Grindleton Parish Council response to planning application for the Duke of York Grindleton

In the application there is a request for change of use on the public house known as the Duke of York.

Drawing Title  
 PROPOSED FIRST AND SECOND FLOOR  
 PLANS

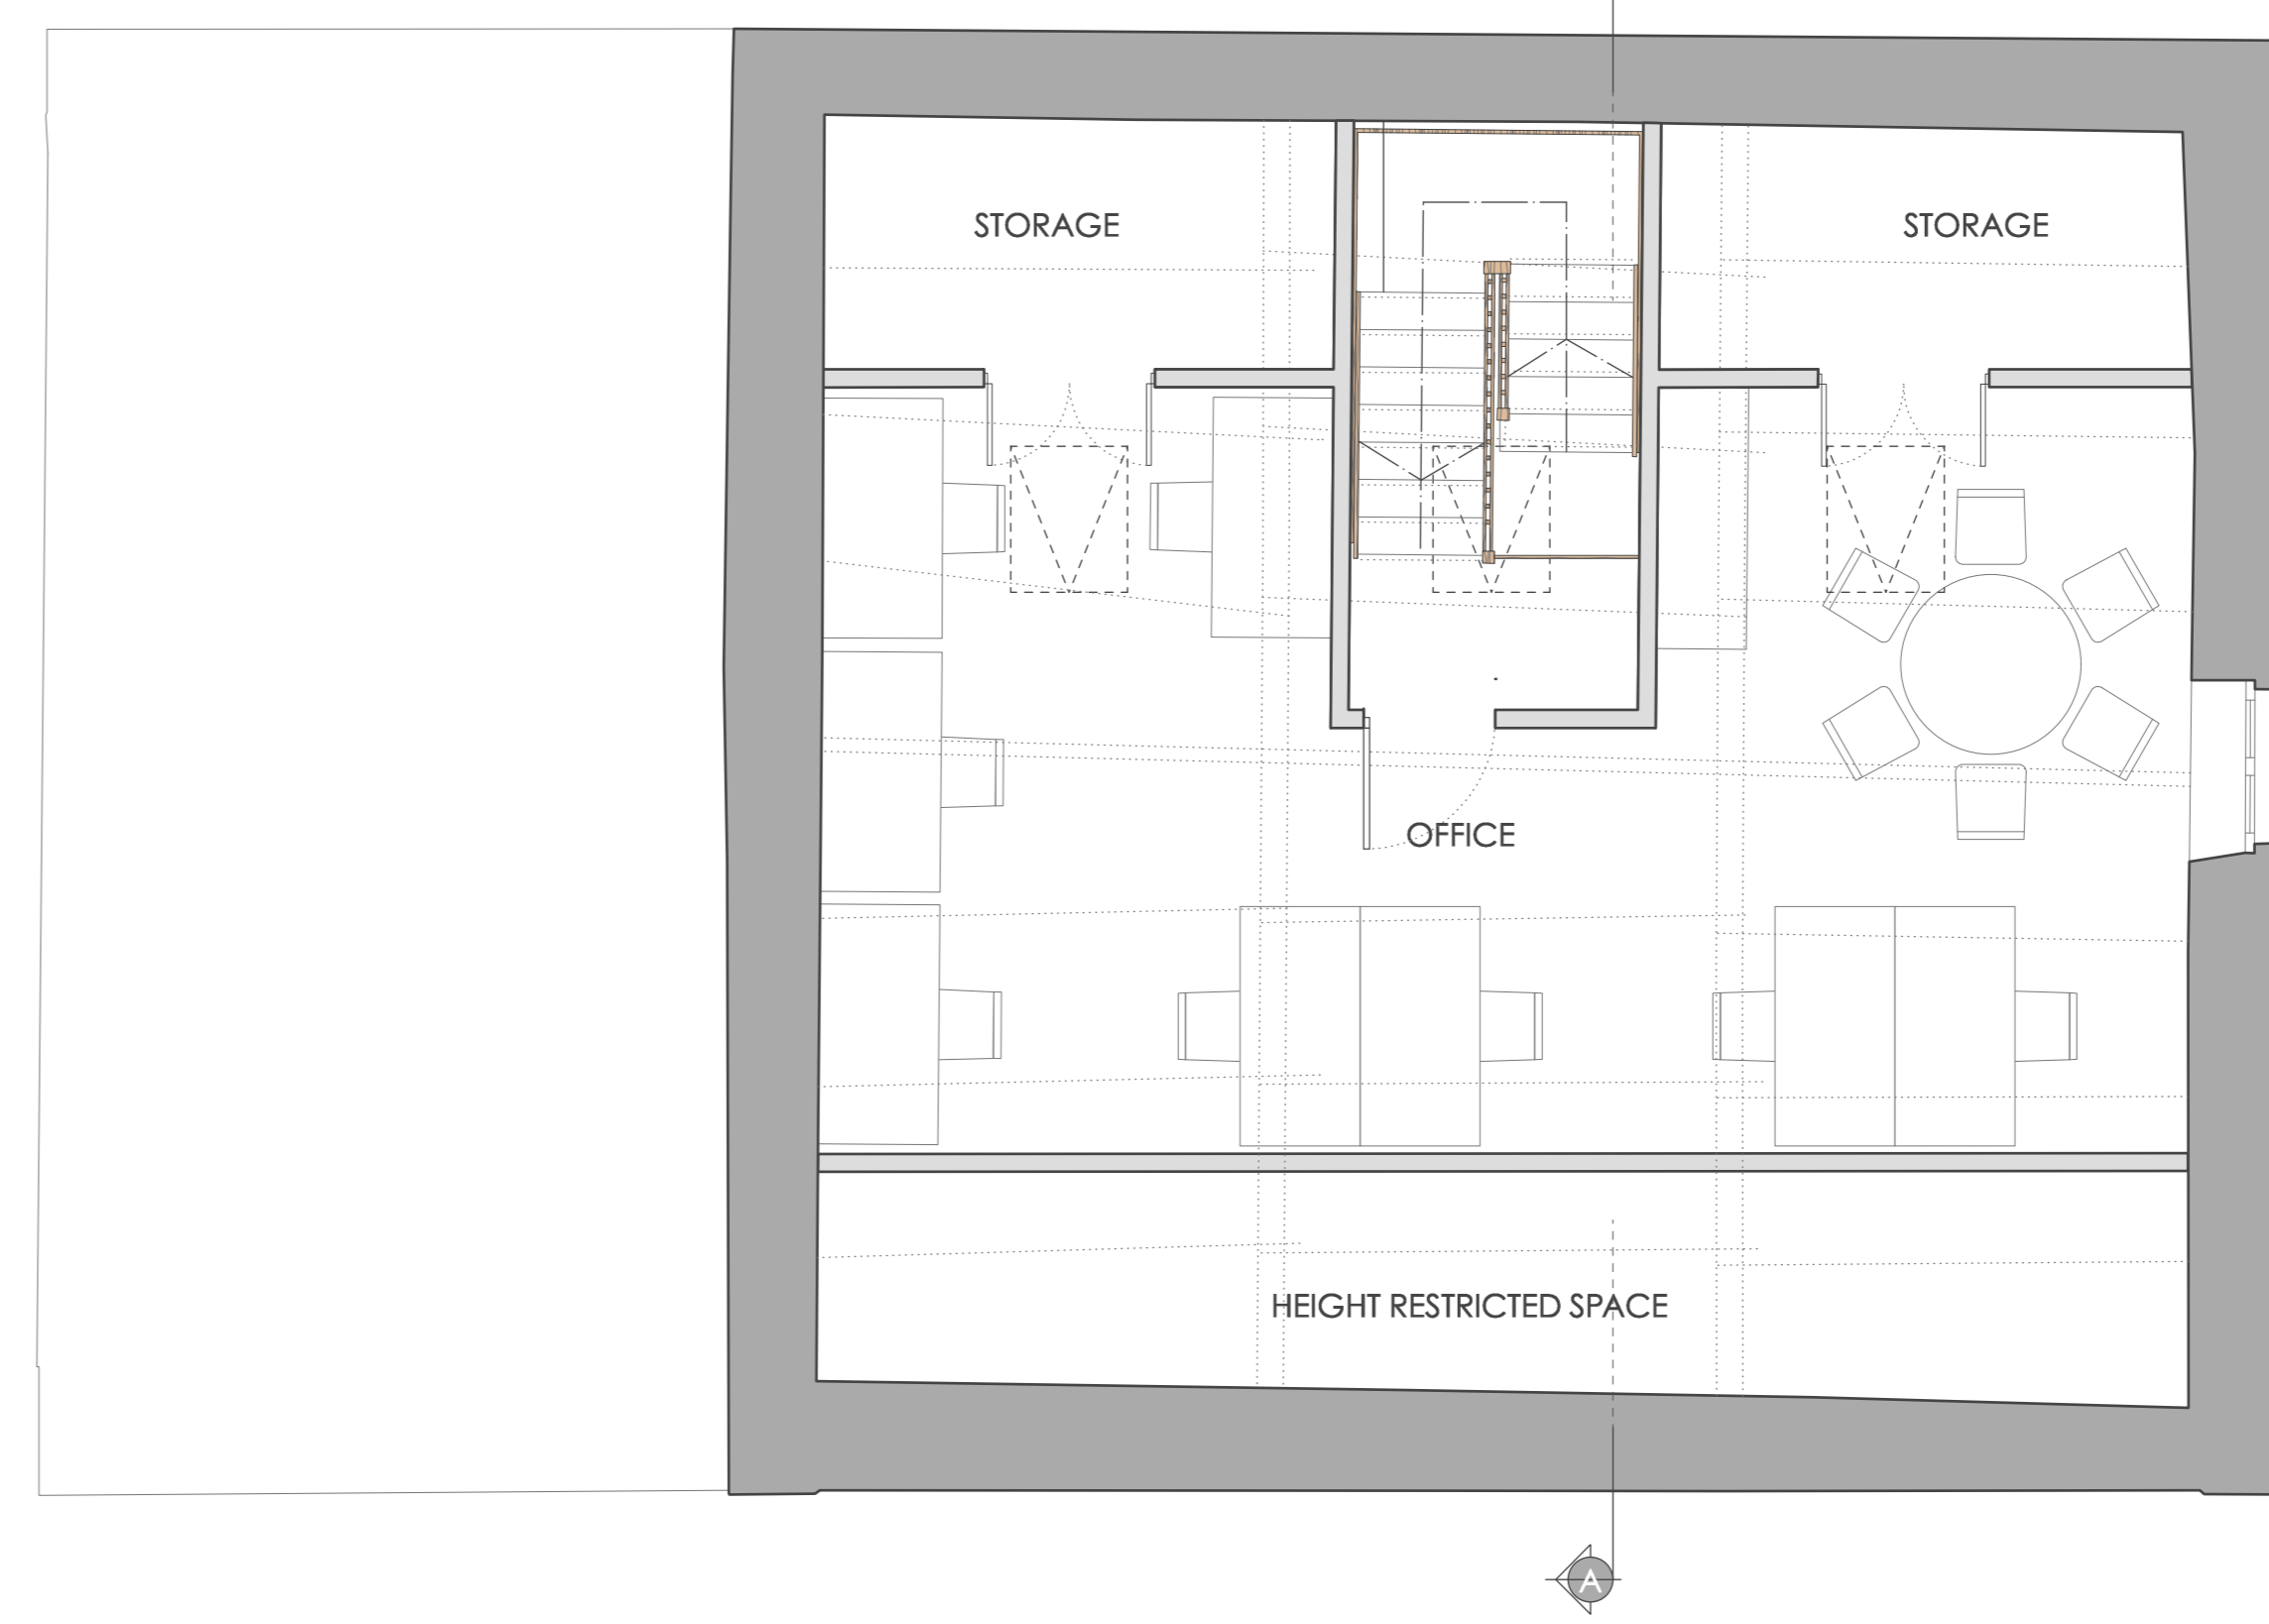
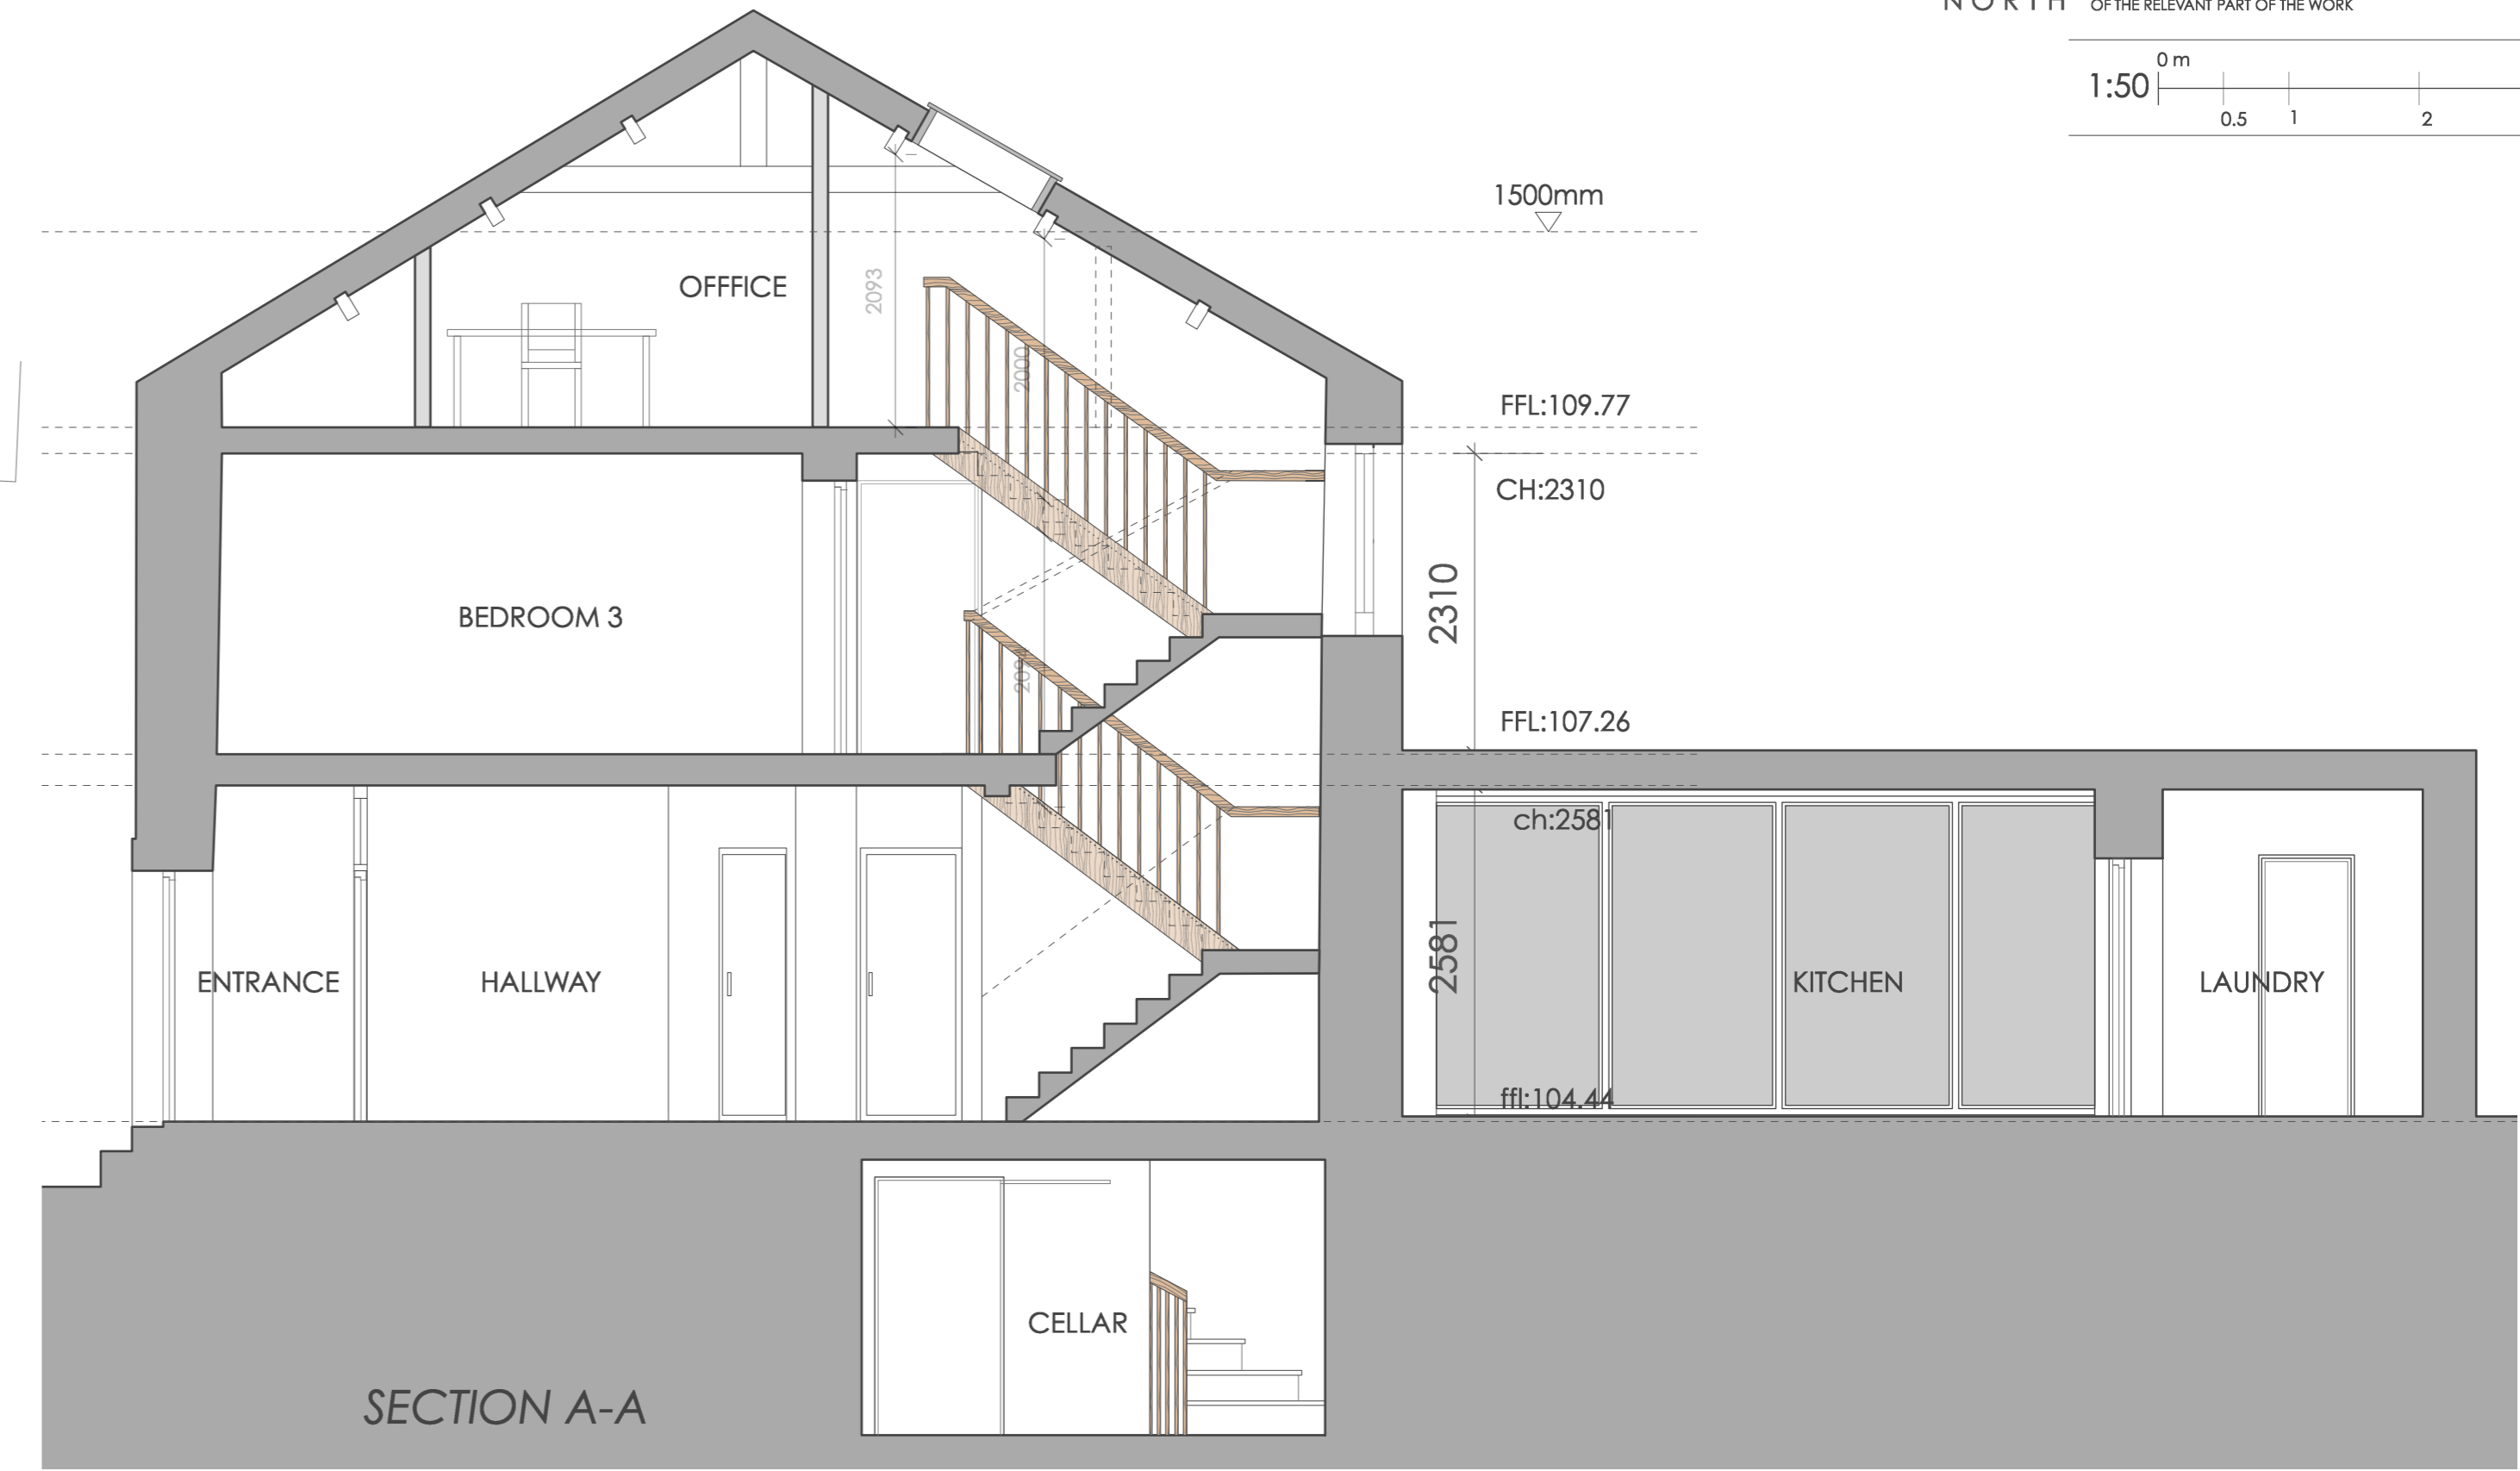
The application states the pub attic will be converted into an office for 8 people. The holiday lets have 3 parking places and can accommodate upto 4 people, with the potential therefore of more than 3 cars in attendance. The depot / store has multiple employees and then there will be family vehicles. Without consideration of visiting reps, deliveries and visitors to the site. We can see that potentially you are up to 14 plus vehicles. On the plans there is clearly not this amount of parking available, this leads us to believe that the site is being over developed.
